WEST SUSSEX COUNTY COUNCIL CONSULTATION

TO:	Arun District Council FAO:James Cross
FROM:	WSCC - Highways Authority
DATE:	10 June 2021
LOCATION:	Folly Foot Farm Fontwell Avenue Chichester PO20 3RU
SUBJECT:	BN/42/21/PL Demolition of existing dwelling, garage & commercial buildings & erection of replacement dwelling, garage & commercial building (Use Class B1 (E) B8) with associated vehicular accesses from Eastergate Lane & hard and soft landscaping. This site is in CIL Zone HSP2 (Zero Rated) & is a Departure from the Development Plan.
DATE OF SITE VISIT:	n/a
RECOMMENDATION:	More Information
S106 CONTRIBUTION TOTAL:	n/a

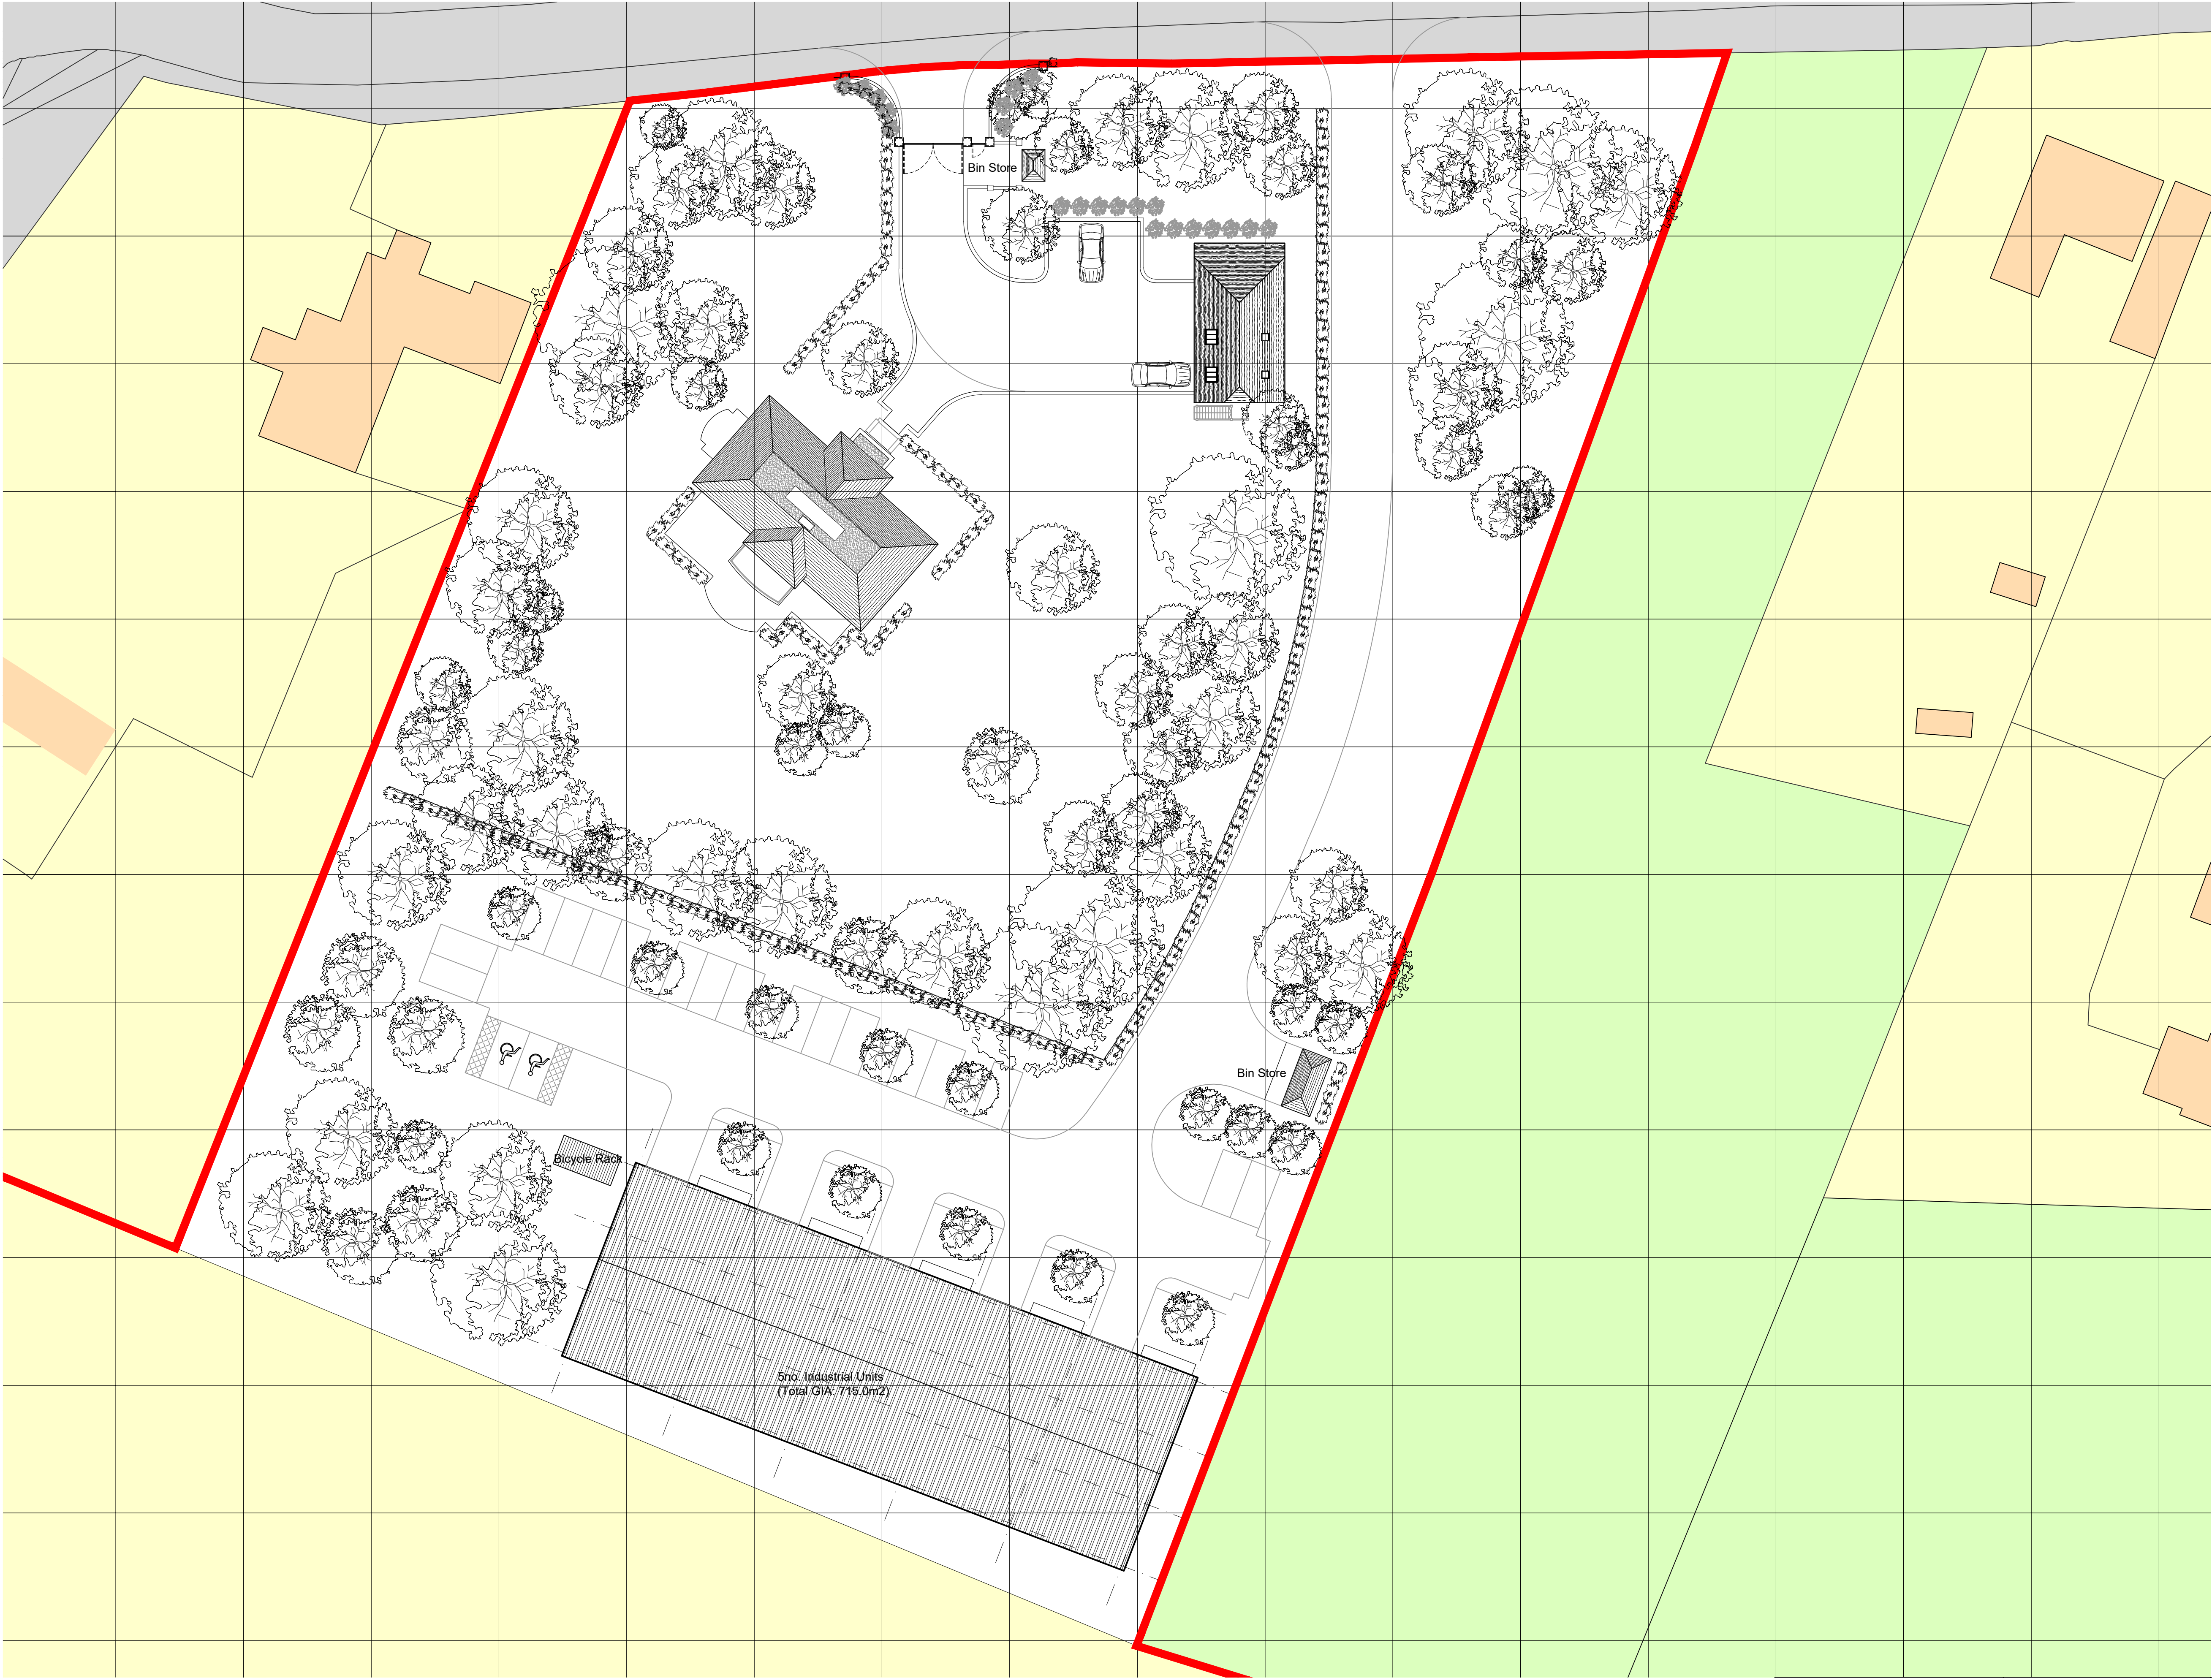
I note the presence of a layby/overgrown accessway within close proximity to the north-east of the site, however this has not been shown on any of the proposed plans. The applicant is requested to demonstrate this on a revised plan.

The proposed site plan demonstrates parking provision of 17 parking spaces plus 2 parking spaces for disabled use. The proposed bays accord with the minimum requirements of 2.4 x 4.8m per single bay as outlined in Manual for Streets (MfS) guidance. The disabled space includes an extra 1.2m wide hatching at the access aisles. The frontage of the building as stated in the Planning Document will be used as loading bays. There is space of at least 6m beyond each parking bay to allow vehicles to turn and exit in forward gear onto the public highway.

The proposed vehicle tracking plan conflicts with the above and demonstrates 24 parking spaces. The WSCC Car Parking Guidance for the proposed E/B8 use would be 1 space per 30sqm, subsequently resulting in demand for 24 parking spaces. While it is appreciated that the proposed loading bays across the building frontage can be used as an informal parking, the applicant is requested to clarify the amount of spaces proposed for the commercial use?

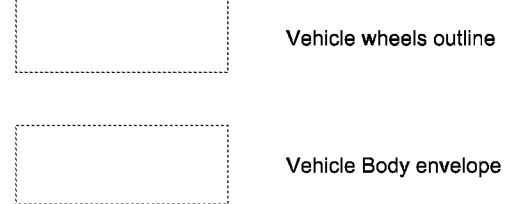
Building Regulations state that fire appliances need to be able to get within 45m of a dwelling and any access way required to get within this distance can only be reduced to 2.75m as a minimum. The actual space required to operate at the scene of a fire is 3.7m. The proposed plan no. 11354/102 Rev P1 demonstrates a Box Van (2.1 x 8m) successfully manoeuvring from/to the site onto Eastergate Lane.

The proposed plan no. 11354/102 Rev P1 demonstrates a Rigid Truck (2.5 x 12m) successfully manoeuvring to the site onto Eastergate Lane. The truck is slightly overrunning the carriageway when entering the site, however given the size of the truck and the road context this is not anticipated to result in highway safety issue.
